## **Response to Planning Application**

**Application ref:** A/193/20/PL

**Description:** Erection of a 1 No. 3 bedroom chalet bungalow & detached garage. This site is in CiL Zone 3 and is CIL Liable as dwelling.

**Location:** Ham Manor Cottage Ham Manor Way Angmering BN16 4JQ

Revision:	A	Dec 2020	Dimension added
address	Ham Manor Cottage, Ham Manor Way, Worthing, West Sussex		
project	Proposed construction of 3 bedroom detached property with detached double garage		
title	Proposed Block Plan		
scale	date	dwg no.	revision
1:200 on A4		2020.275.02	A

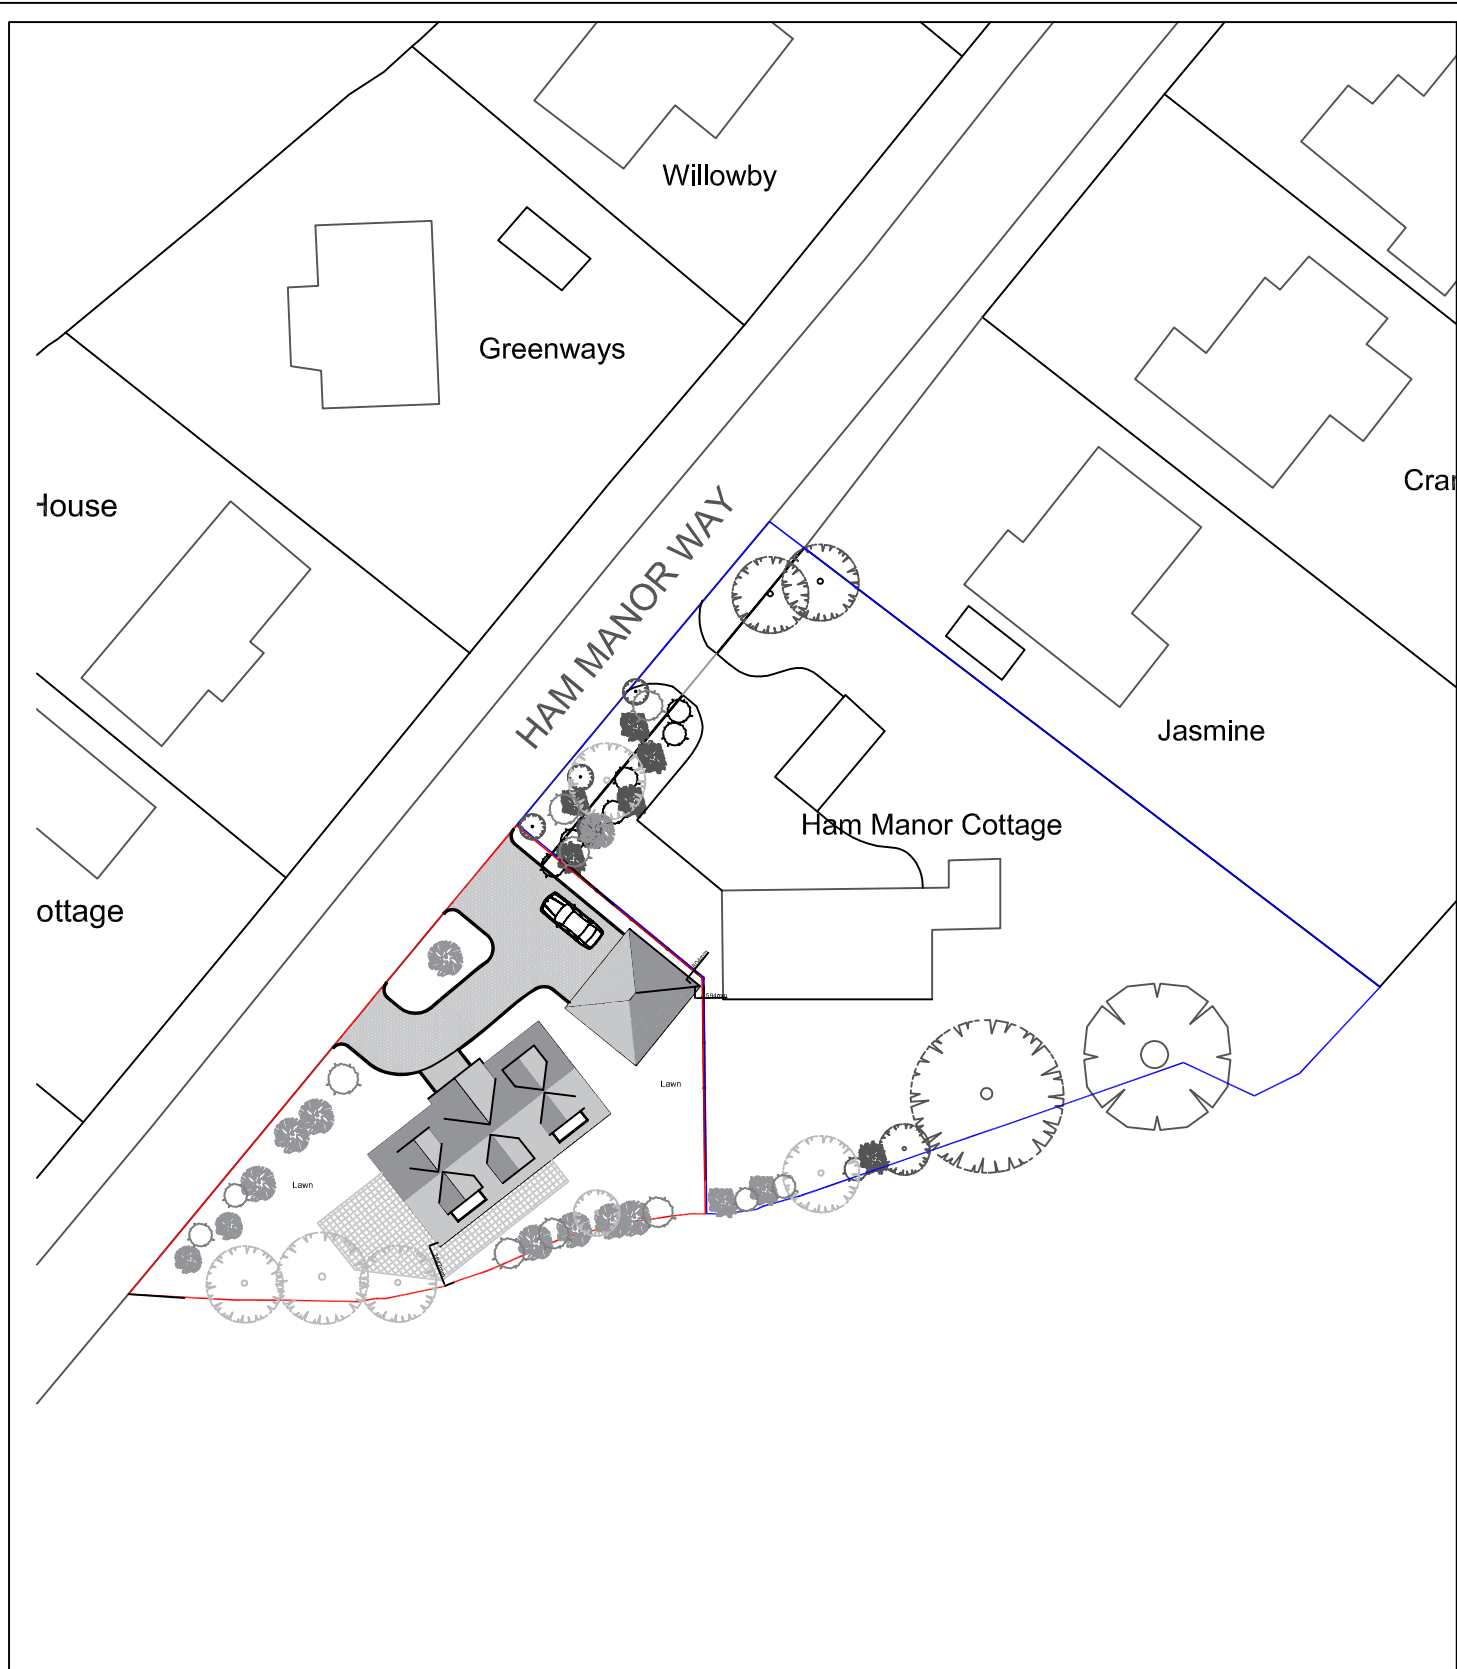
The NPPF para 124/127 relate to good design principles which equally apply to small infill, new and replacement development. The indicative site layout has made reference to indicative planting alongside tree retention. These details would require expanding in the form of a detailed planting plan and specification detailing species choice, actual plant quantities, planting densities and size at time of planting.

Detail should also be provided regarding existing trees and boundary planting, the site red line boundary appears to contain verge edge and associated planting, this would require further detail to show how this area is to be protected in order not to affect the street scene in this location. This is a rural setting within the golf course and this plot forms the gateway to the further dwellings so landscaping needs to reflect in a sympathetic way this rural fringe and change from garden plot to dwelling setting.

I would recommend no landscape objection to the proposals subject to submission of landscape details to provide ornamental and native improvements and biodiversity gain. To confirm tree protection methods and existing verge boundary planting in relation to within and beyond the site boundary that may be affected by the development proposals.
